NORWICH TO TILBURY

EN020027

Comments on Submissions received at Deadline 1

Suffolk County Council [REDACTED]

Print Date: 01-20-26 11:05:13 **COPYRIGHT:** NOT TO BE REPRODUCED WITHOUT THE WRITTEN PERMISSION OF NATIONAL GRID ELECTRICITY TRANSMISSION Plc

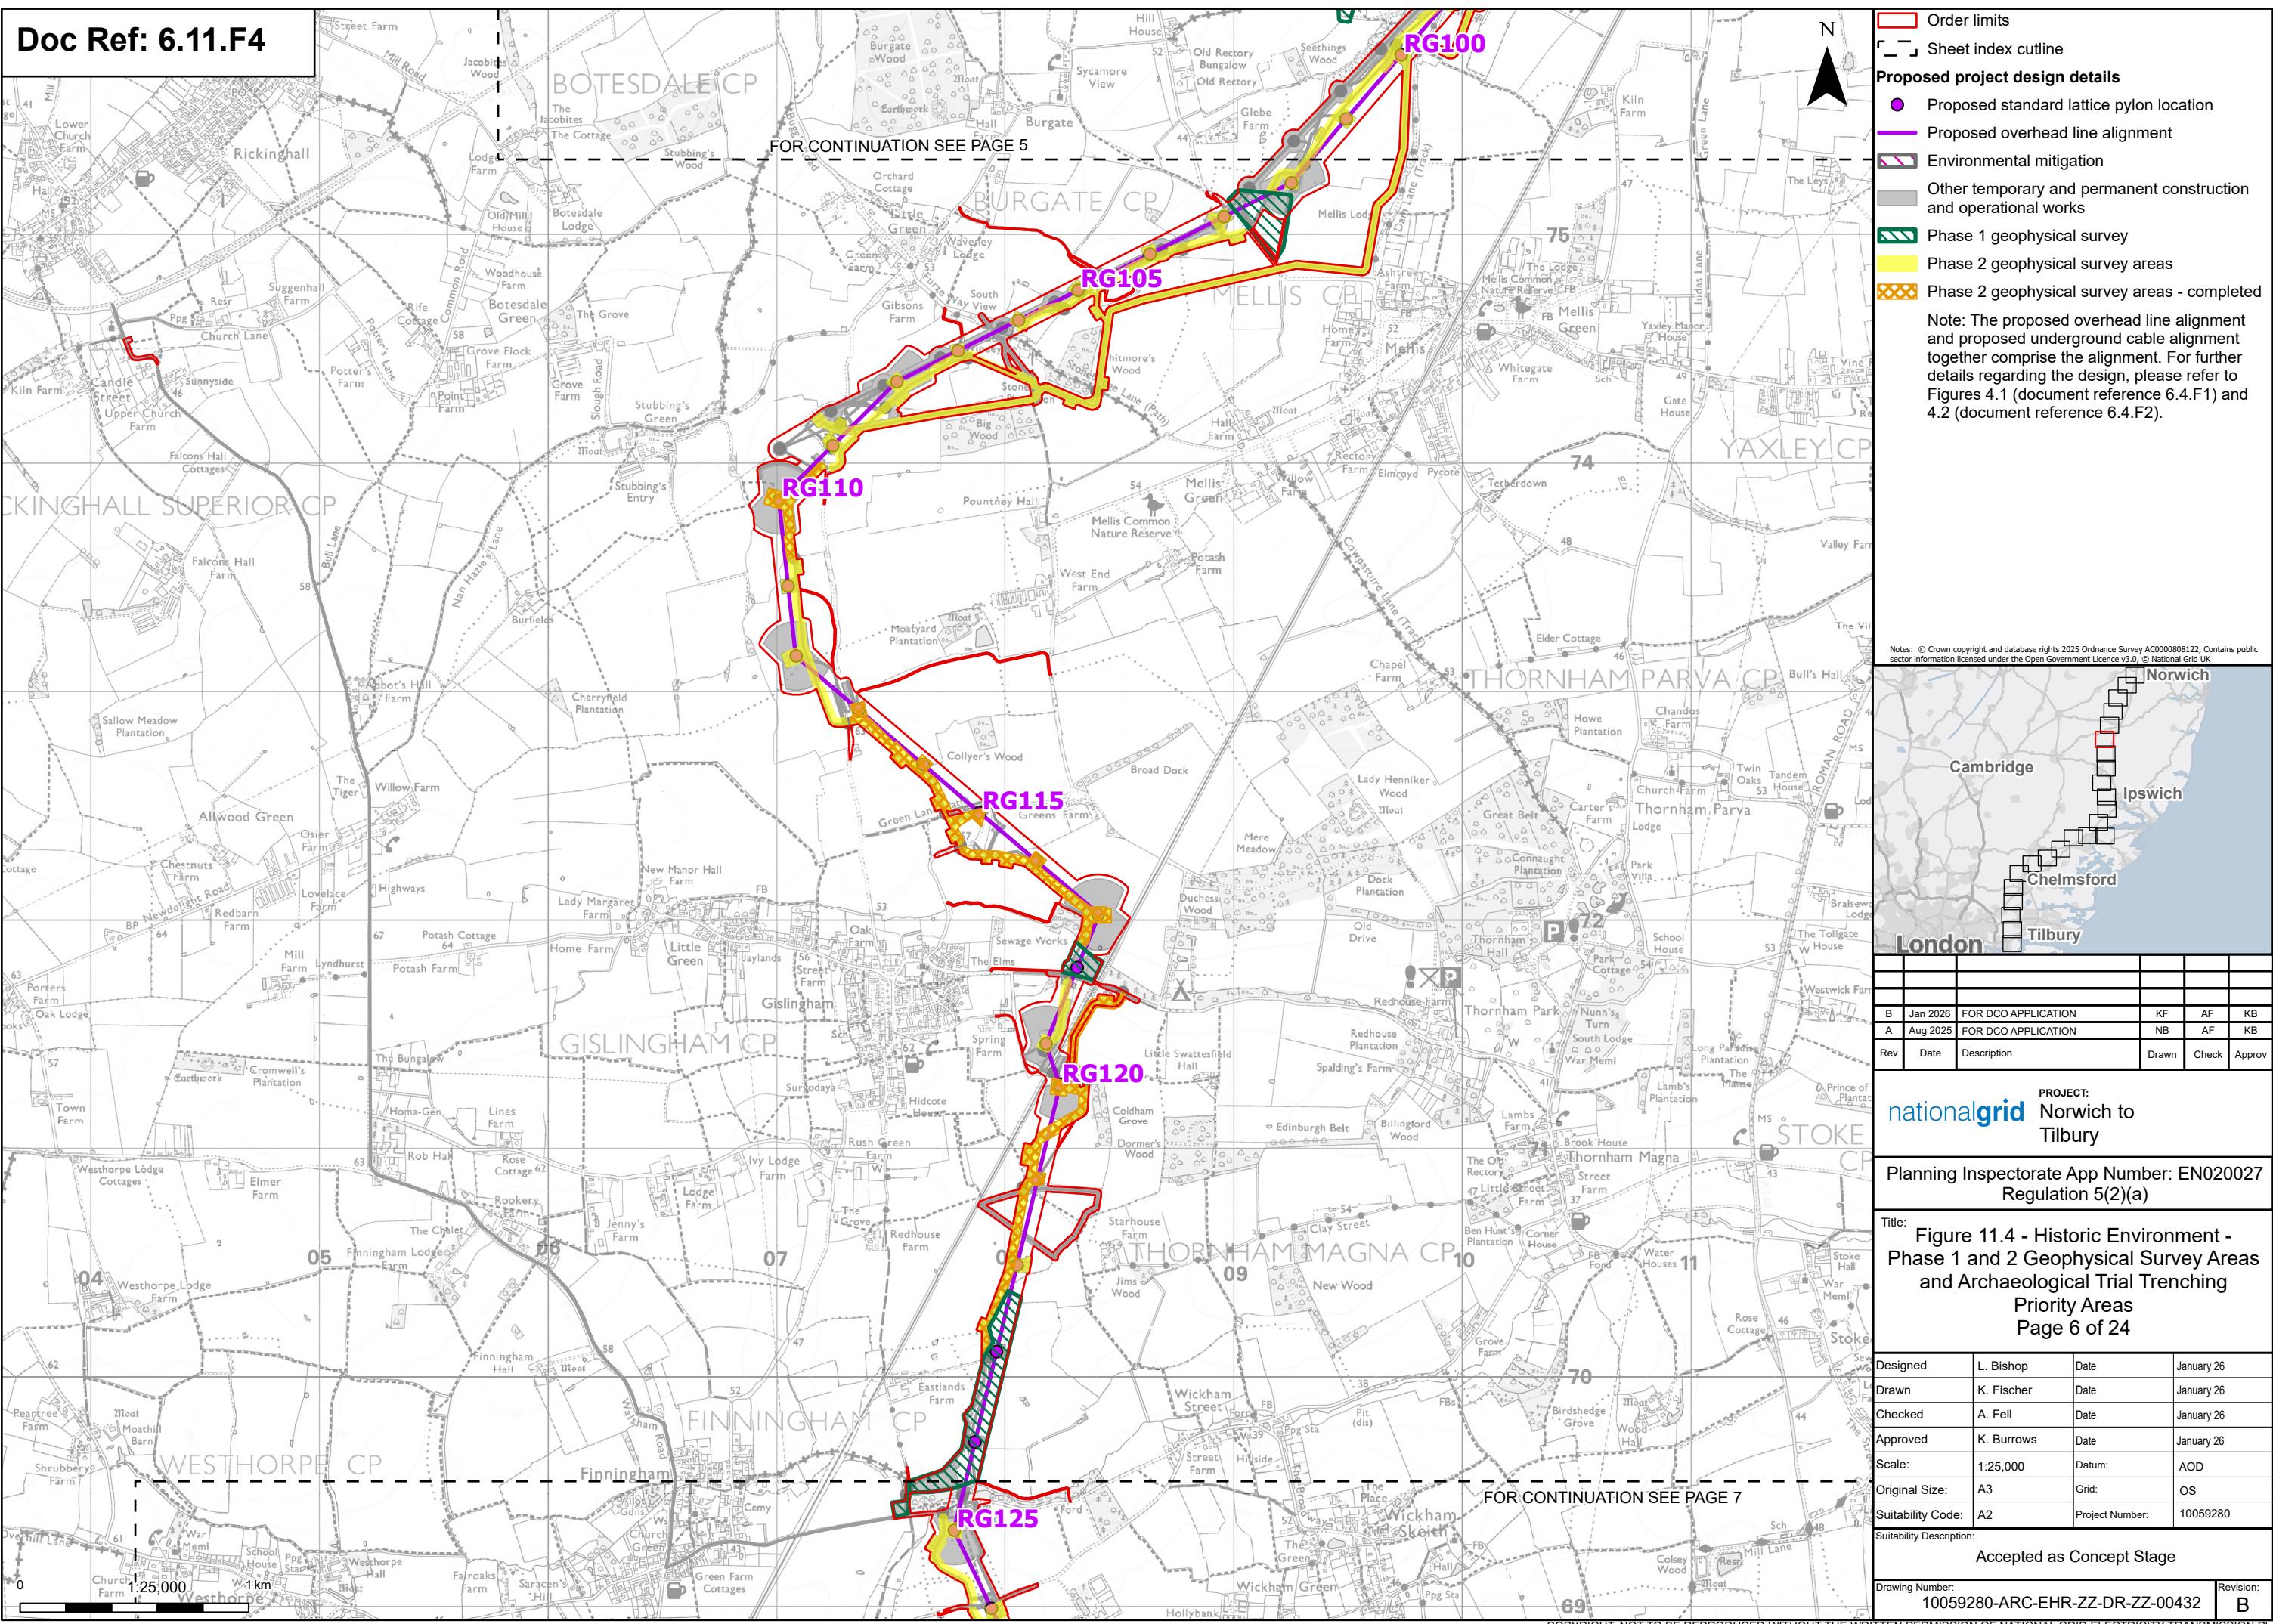
DCO requirement wording in Chapter 14 of the Joint Local Impact Report [REP1-178] .	
5.14	Historic Environment - Archaeology	<p>Table AB (24-25)</p> <p><i>“The Supplementary Environmental Information includes a Project-wide figure indicating the progress of the priority evaluation areas and Phase 2 geophysical survey (6.11.F4 Environmental Statement Figure 11.4 - Phase 1 and 2 Geophysical Survey Areas and Archaeological Trial Trenching Priority Areas [AS-082]). The Applicant proposes to update 7.5 Outline Archaeological Mitigation Strategy and Outline Written Scheme of Investigation [APP-328] during the examination phase in consultation with the Local Planning Authority Archaeological Advisors, which will include figures detailing the completed and planned evaluation.”</i></p>	<p>SCCAS notes this comment in relation to submitted figure 6.11.F4 Environmental Statement Figure 11.4 - Phase 1 and 2 Geophysical Survey Areas and Archaeological Trial Trenching Priority Areas [AS-082]</p>	[AS-082]

5.15	Historic Environment - Archaeology	<p>Table AB (26)</p> <p><i>“The Supplementary Environmental Information includes a Project-wide figure indicating the progress of the priority evaluation areas and Phase 2 geophysical survey (6.11.F4 Environmental Statement Figure 11.4 - Phase 1 and 2 Geophysical Survey Areas and Archaeological Trial Trenching</i></p>	<p>SCCAS reiterate that the Applicant must submit an amended 7.5 Outline Archaeological Mitigation Strategy and Outline Written Scheme of Investigation [APP-328] in reasonable time during the examination, incorporating LPA archaeological advisor comments. Allowing sufficient time for the LPA archaeological advisors and Historic England to comment on the document. The document must be approved by the</p>	[APP-328]

<p><i>Priority Areas [AS-082]). The Applicant proposes to update 7.5 Outline Archaeological Mitigation Strategy and Outline Written Scheme of Investigation [APP-328] during the examination phase in consultation with the Local Planning Authority Archaeological Advisors, which will include figures detailing the completed and planned evaluation.”</i></p>	<p>Local Authority Archaeological Advisors (Norfolk, Essex and Suffolk) and Historic England.</p> <p>If approval of the 7.5 Outline Archaeological Mitigation Strategy and Outline Written Scheme of Investigation [APP-328] cannot be achieved by the time of determination, the DCO must include provision for post-consent approval of the 7.5 Outline Archaeological Mitigation Strategy and Outline Written Scheme of Investigation [APP-328].</p>
